**Response to Highways England Deadline 9 Documents 2.6(a), 2.8(a), 3.1(c), 4.1(a), 4.3(a), 8.94 & 8.98:**

**2.6(a) Traffic Regulation Measures Plans Part 2 Speed Limits**

**2.8(a) Engineering Drawings and Sections**

Plot Date: 15 November 2019 09:39:12
File Name: NUGIS Team M42 Junction 6_MXD_Land Plans 20191113\HE551485-ACM-GEN-ZZ_SW_DCO_ZZ-DR-DC-2208.mxd

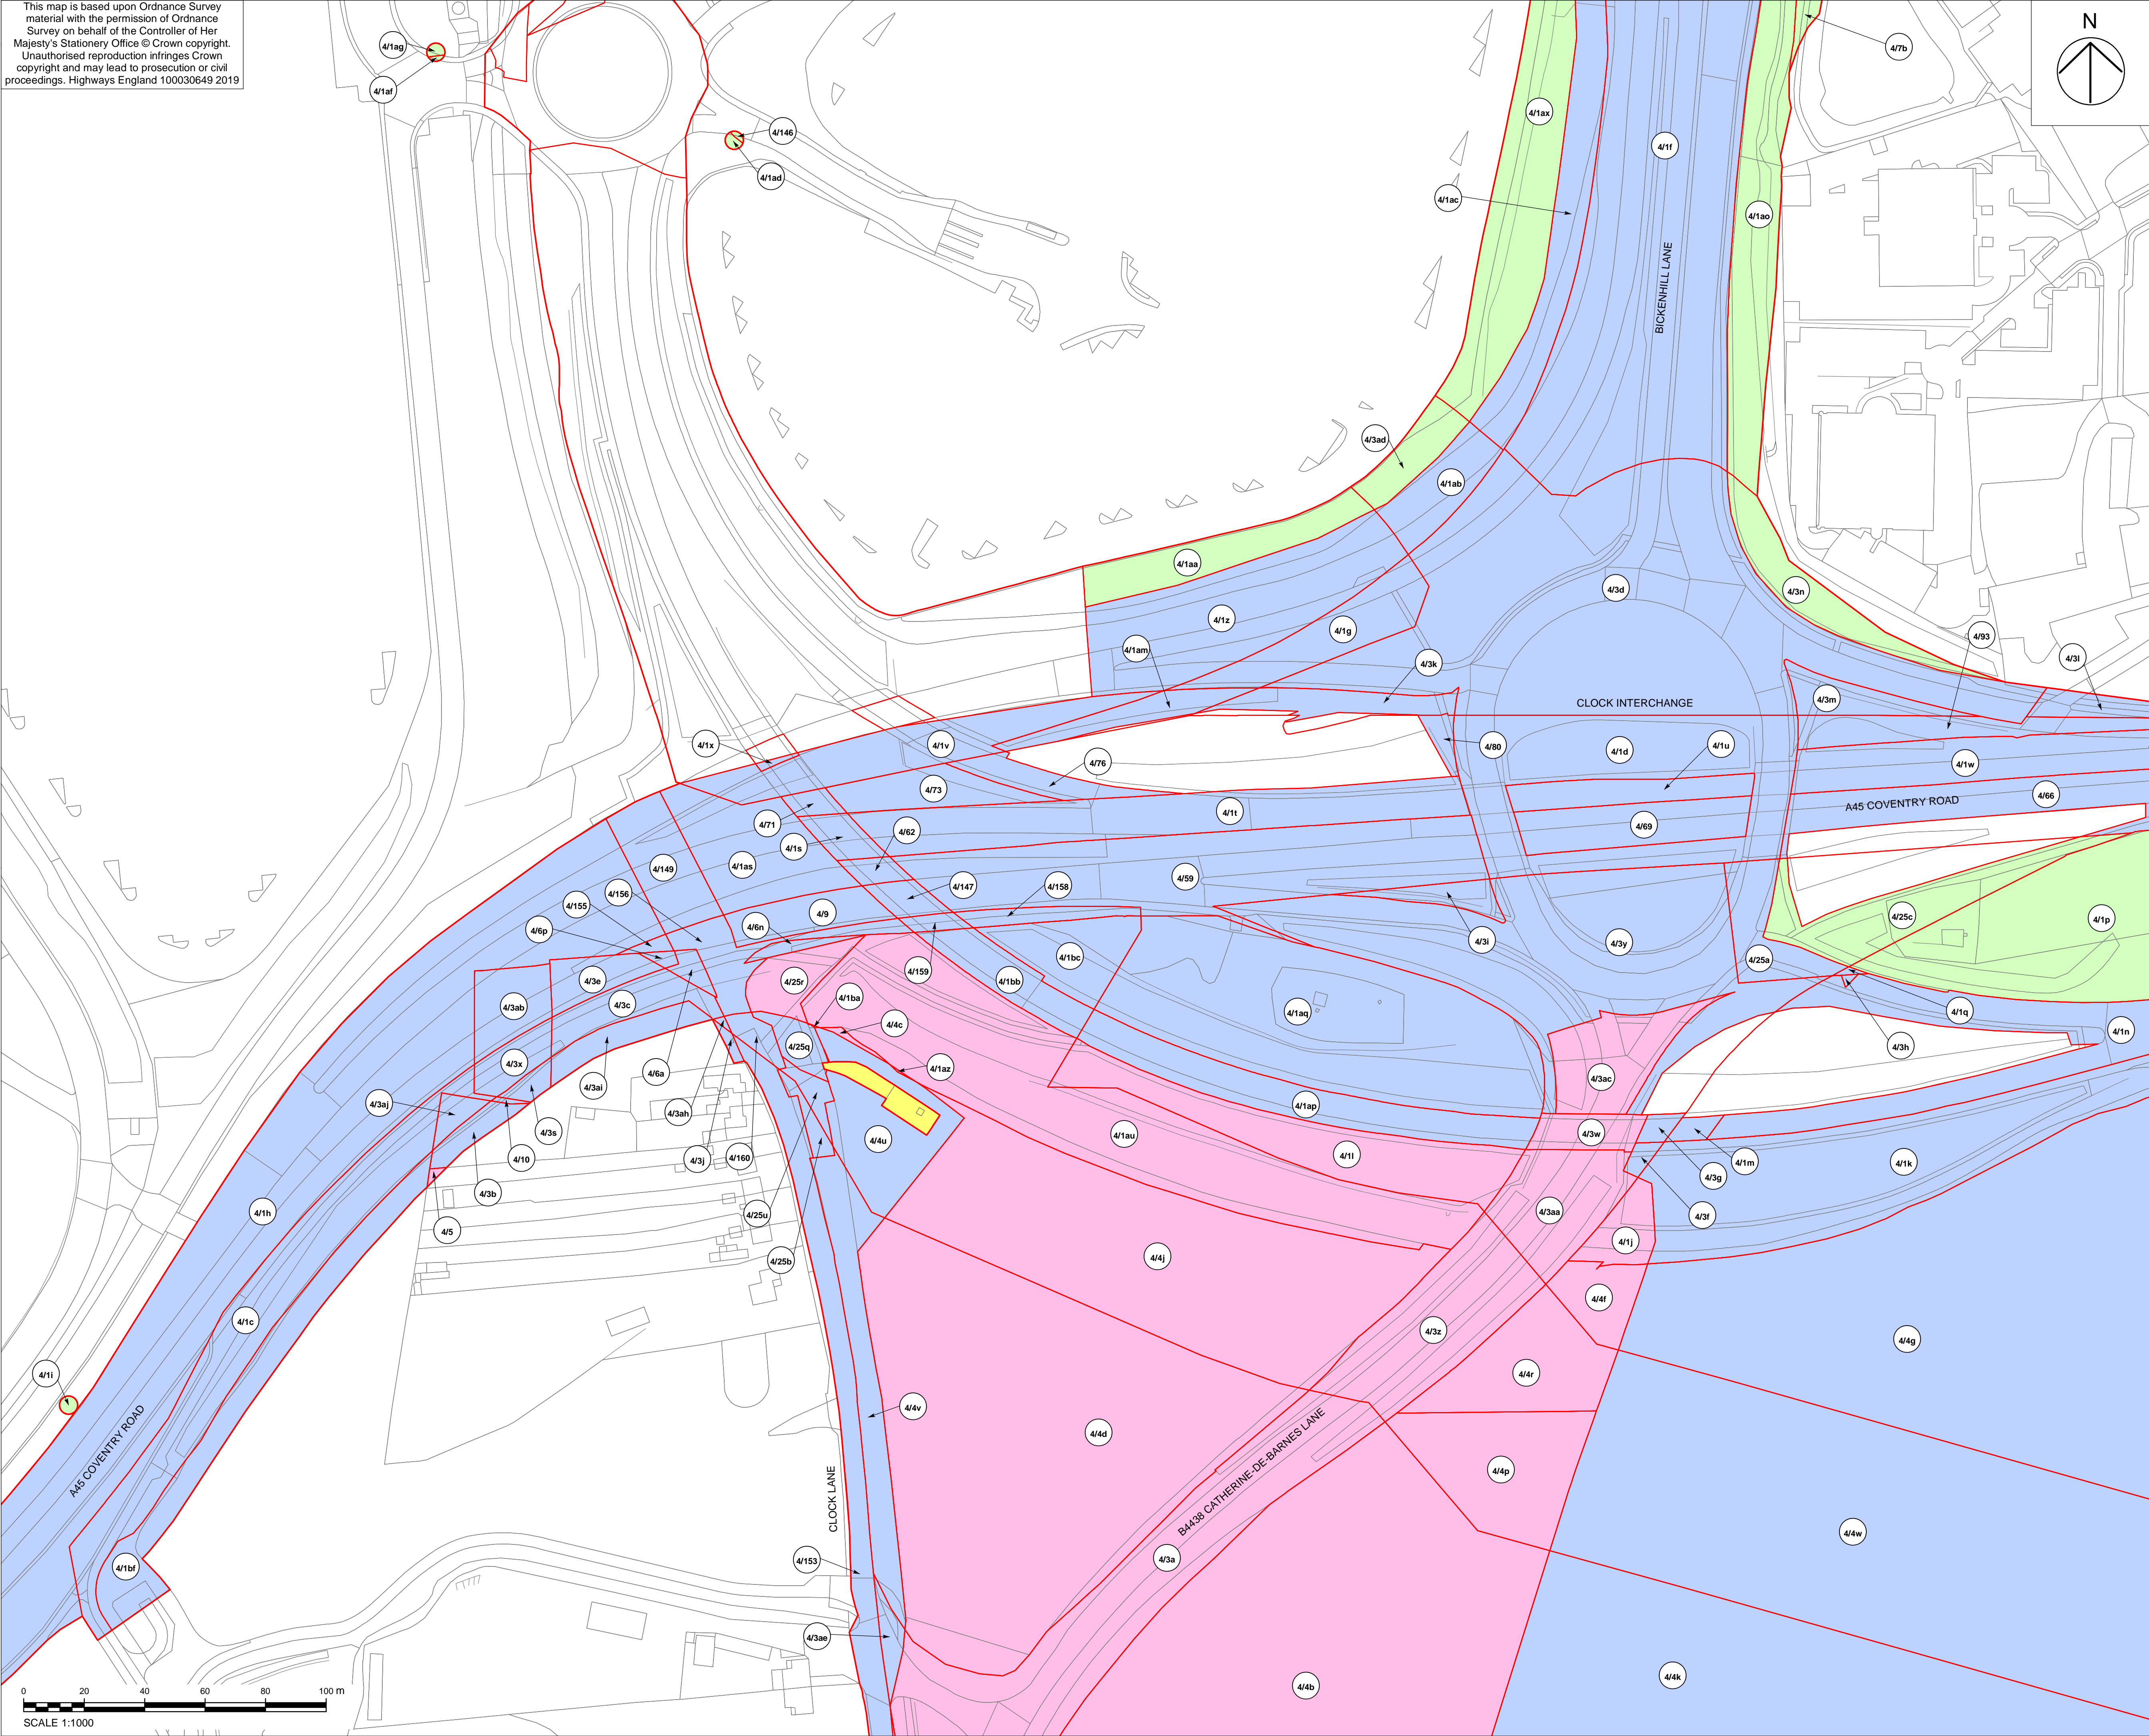
We believe we also own the subsoil rights to plot 2/10h and plot 2/10j which runs in front of my property as shown previously.

**POR COMMENTS:**  
 Plot 2/76b includes a strip of land around my boundary which we have occupied and exclusively used for 20+ years and indeed the area is fully enclosed by the fencing we erected. HE have been made aware of the facts but this has not been included in any of their documentation.
